EAGLEVIEW SUBDIVISION CONSTRUCTION DOCUMENTS

PCD FILE #: SF-22-42

EAGLEVIEW
EL PASO COUNTY, COLORADO
CONSTRUCTION DOCUMENTS
COVER SHEET

**C1.2**

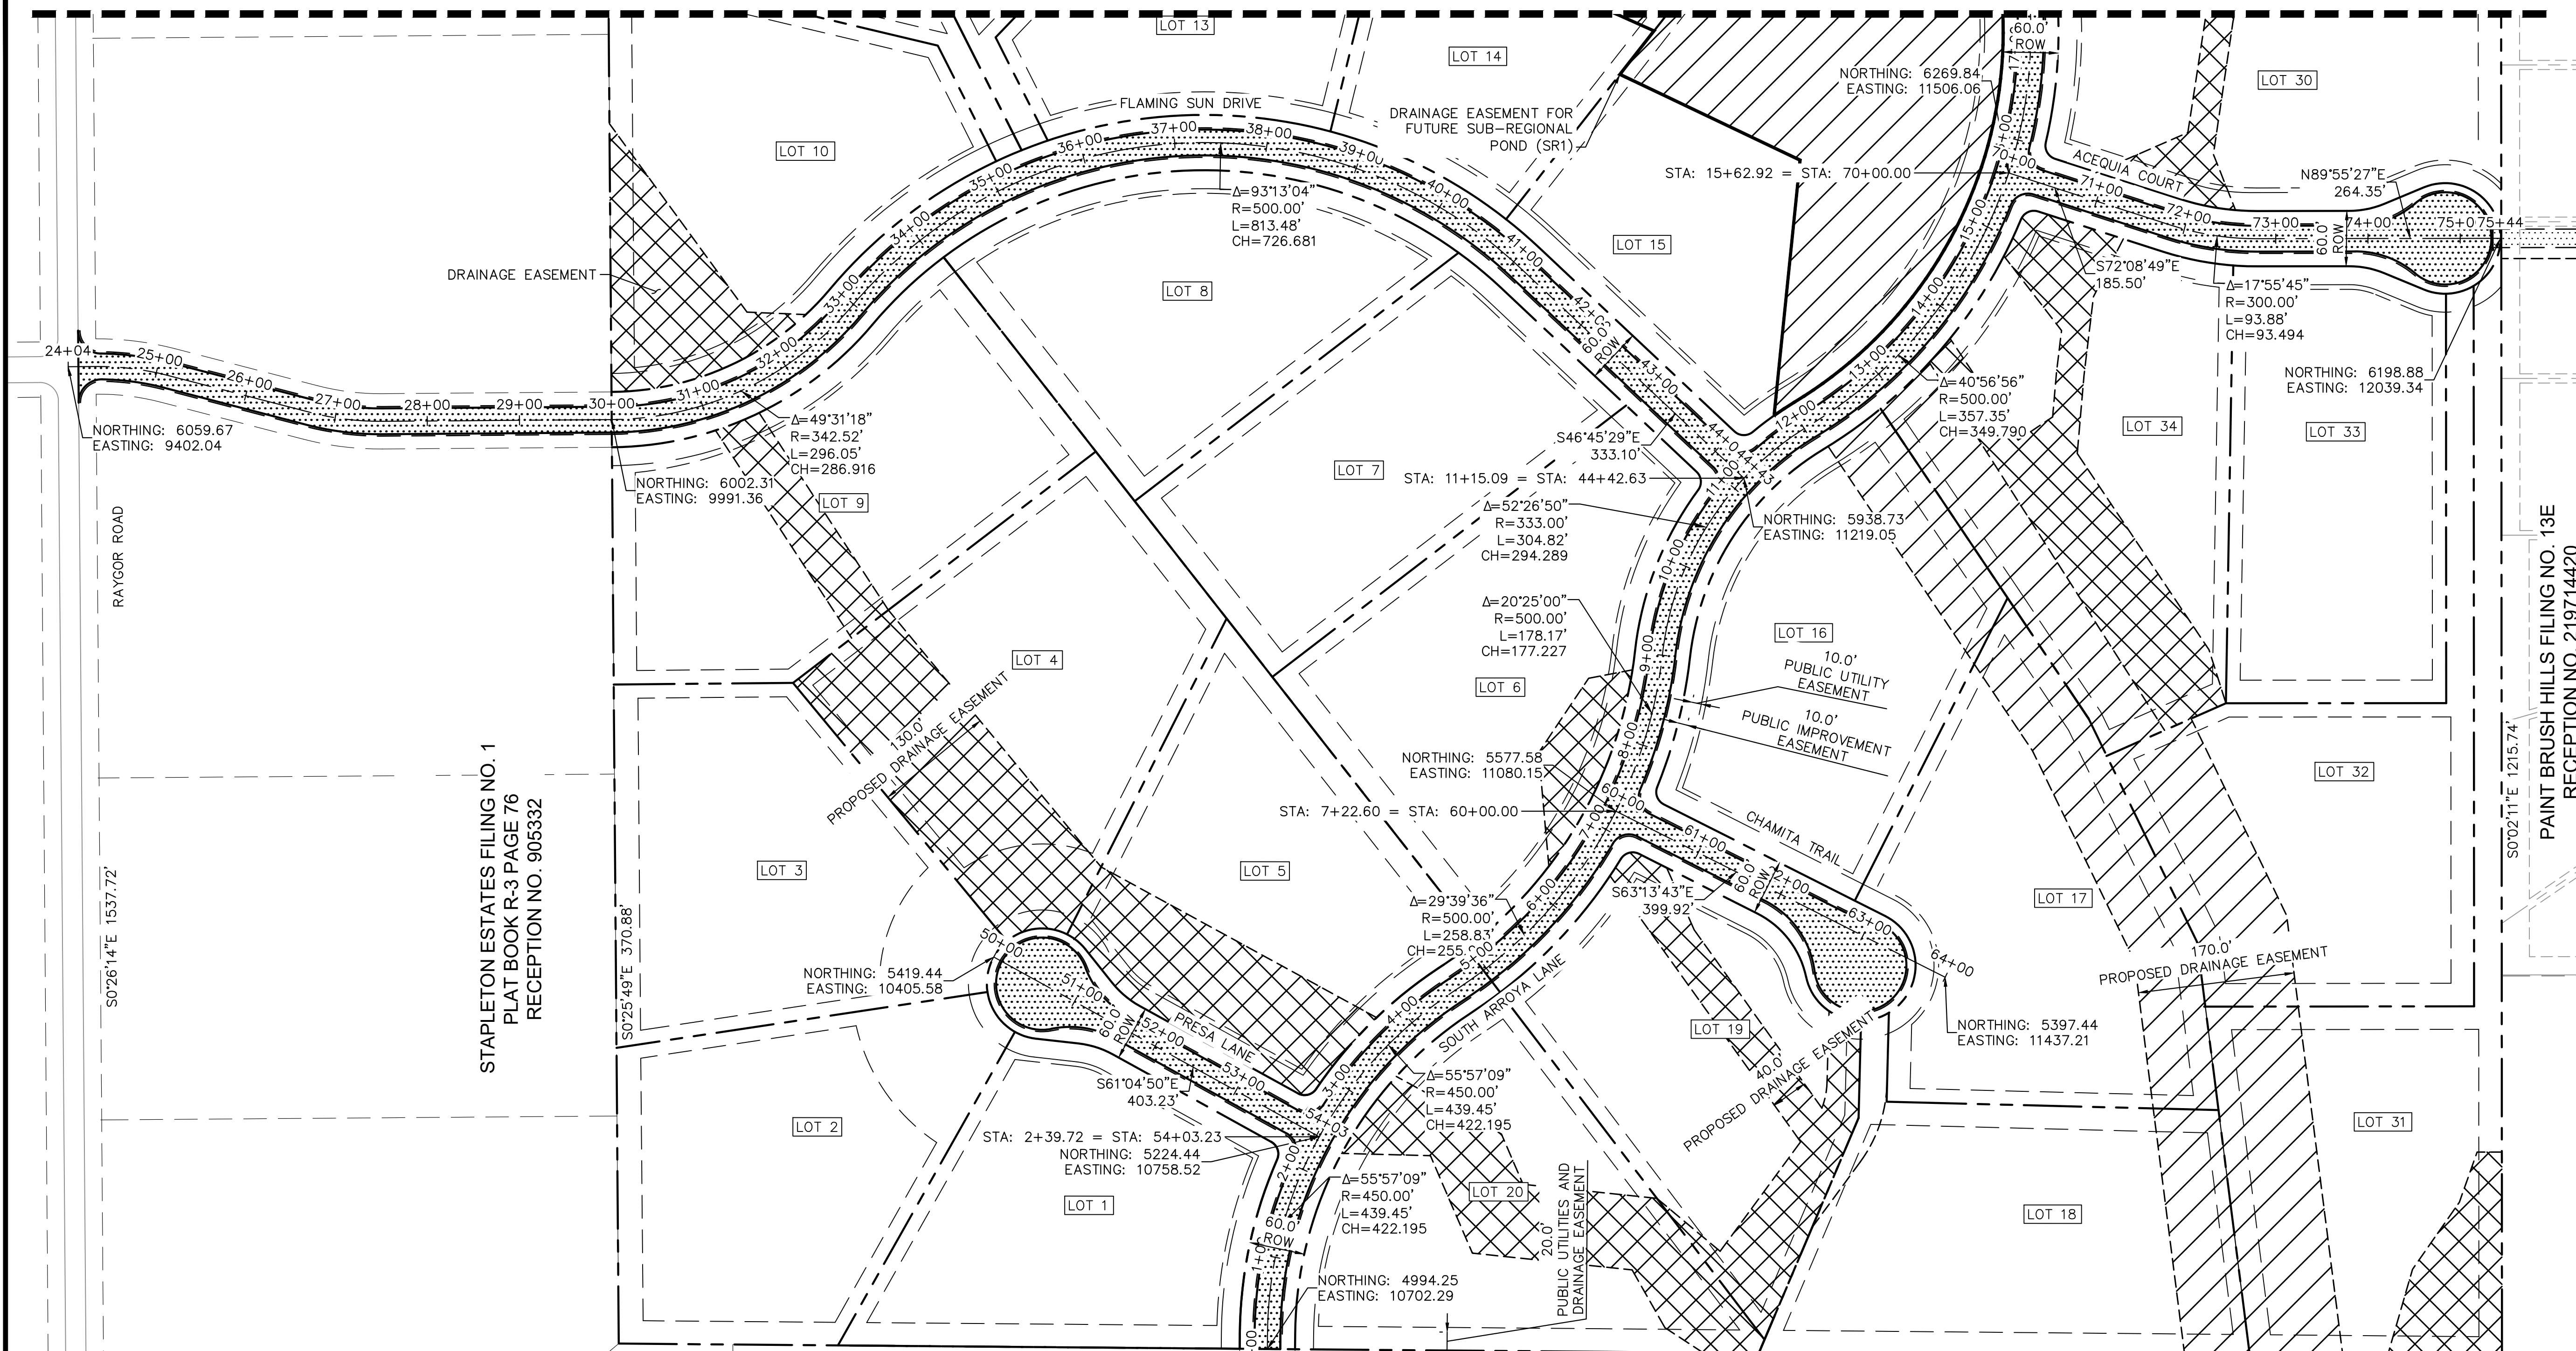
Please provide cross section of the Raygor improvements as
indicated in the TIS and the previously approved deviation request
#3 from the preliminary plan application. Please also see the
previous comment from review #1 (see snippet below)

Provide additional detail. Existing condition of
the road has pavement deterioration which
would need to be removed and replaced in
conjunction with the widening. Update plans to
show the extent of removal. Possibly
coordinate a site visit with the review engineer
to verify areas that needs to be
removed/replaced.
Additionally provide a detail for the sawcut and
"T" cap at the interface between the new and
existing pavement, typical for all road sections
with widening.

label existing and new sections

EAGLEVIEW
EL PASO COUNTY, COLORADO
CONSTRUCTION DOCUMENTS
OVERALL SITE PLAN

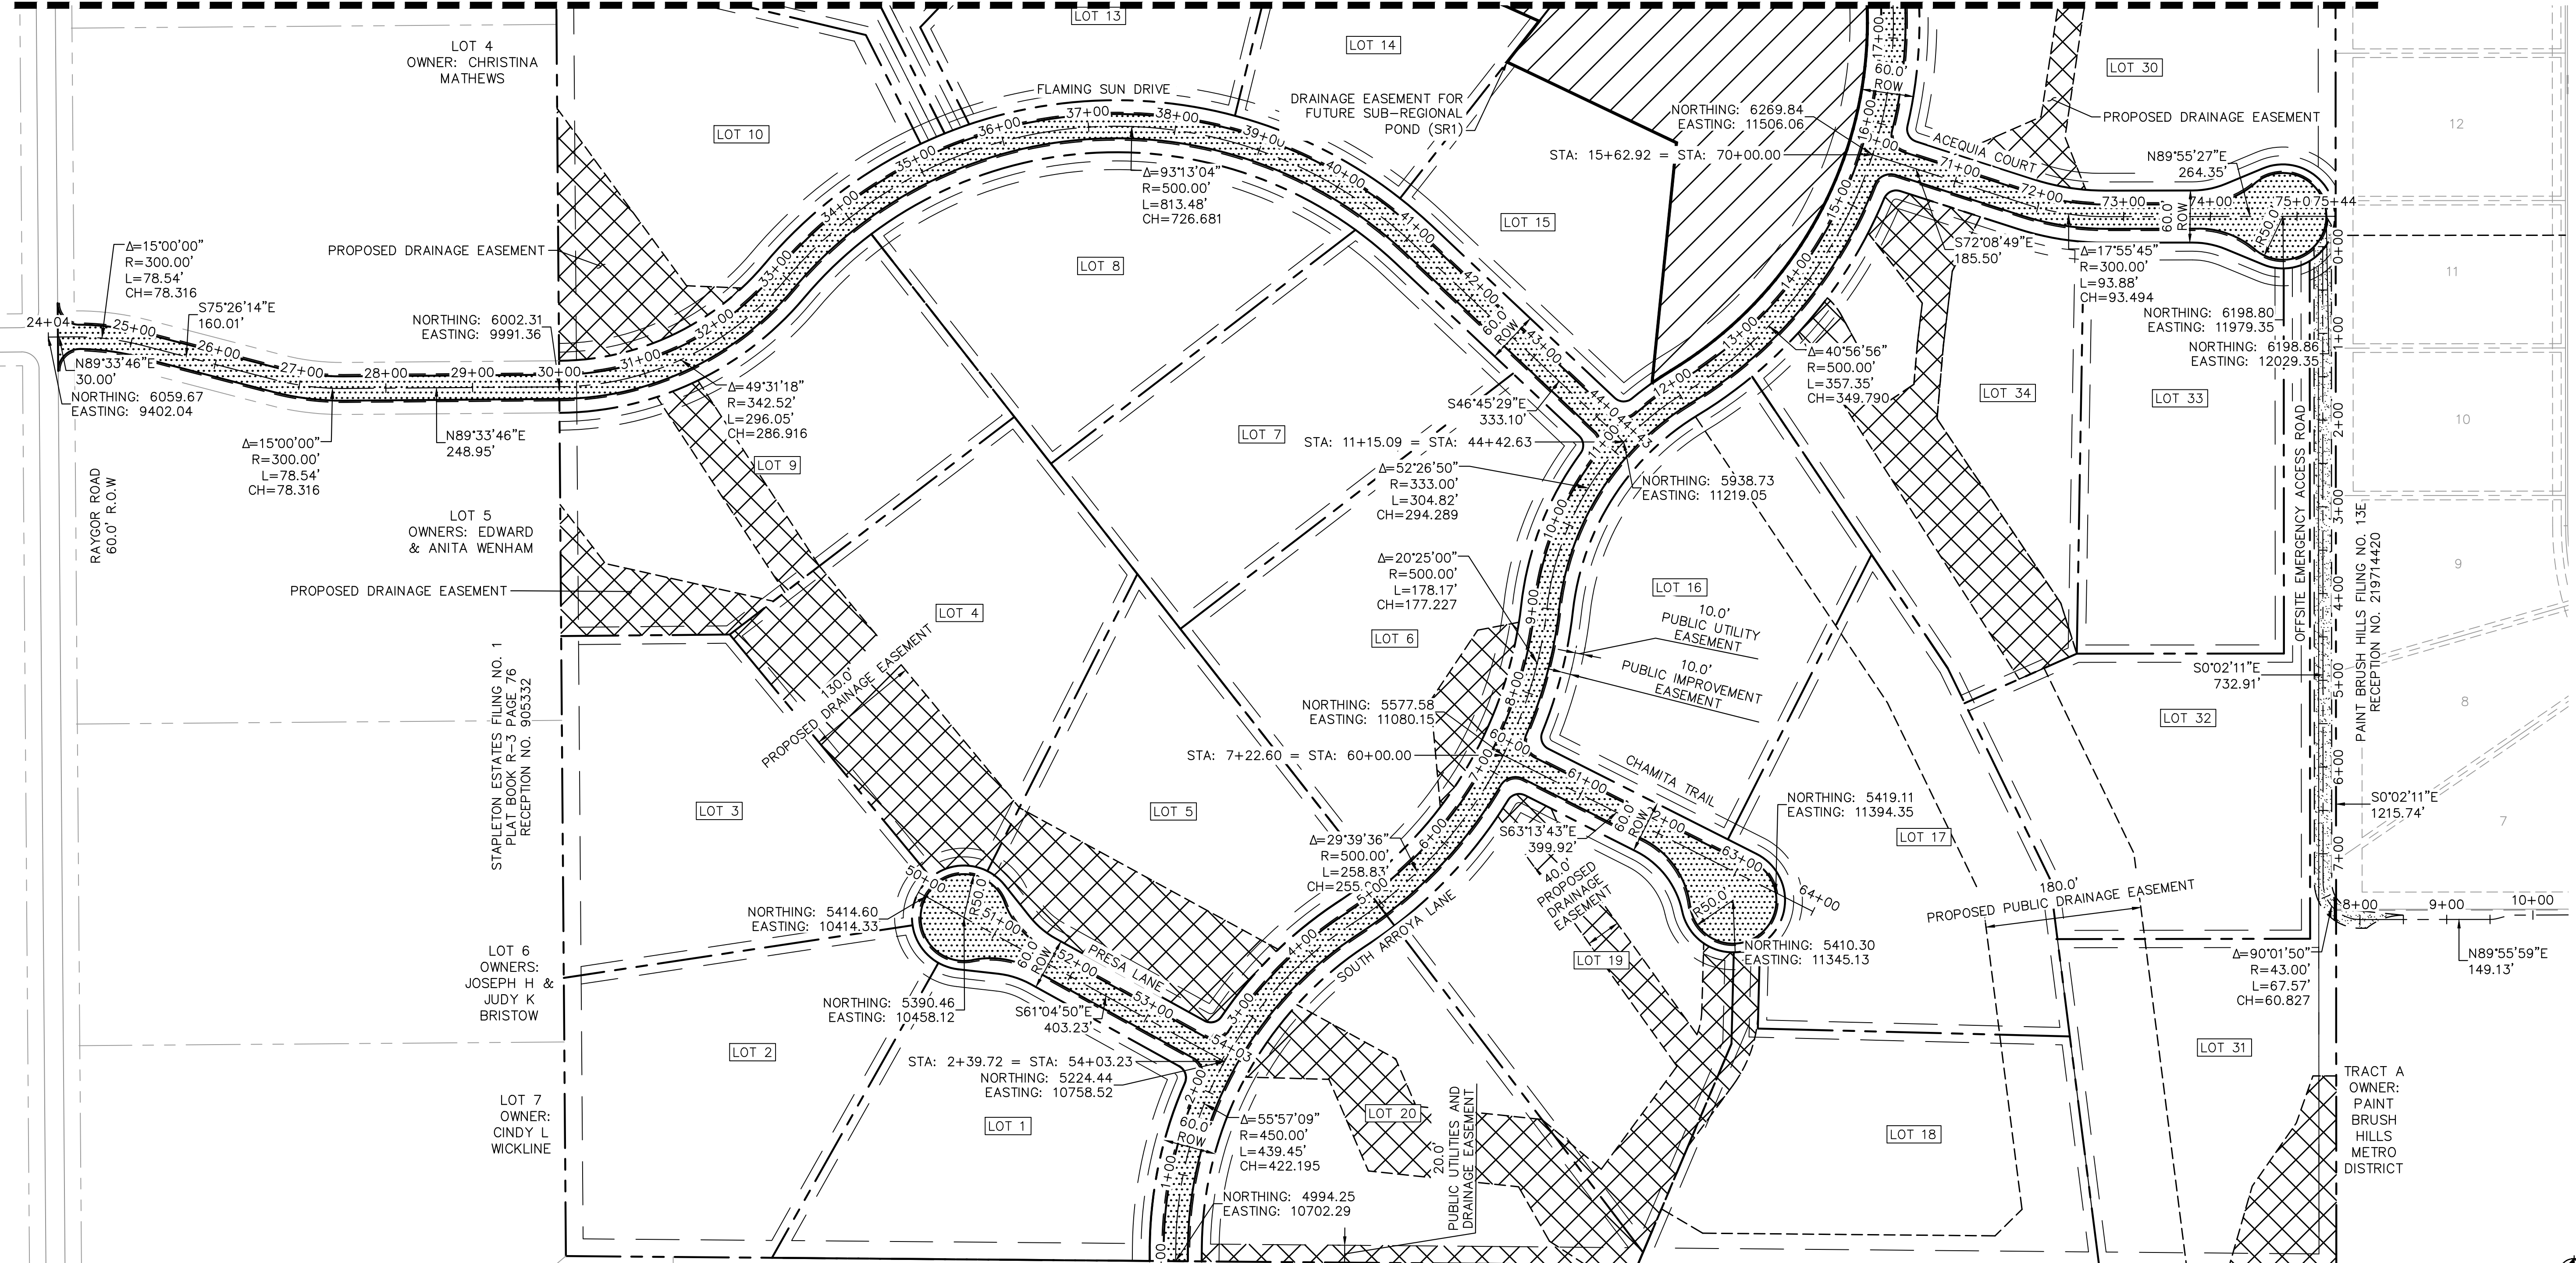
maintenance access road is required on each side of the channel per ECM 3.3.3.K (see highlighted yellow) for channels 30' in top width or more. Please revise.

Also verify the other channels and provide the necessary maintenance access road along the channel per ECM section above. For example Channel H is indicated to have a 39' top width on the drainage calculations and would require access on each side. There are exclusions that may apply per ECM 3.3.3.K.

Identify how access will be provide to these drainage channels for maintenance by the district.

This does not appear to match the plat.
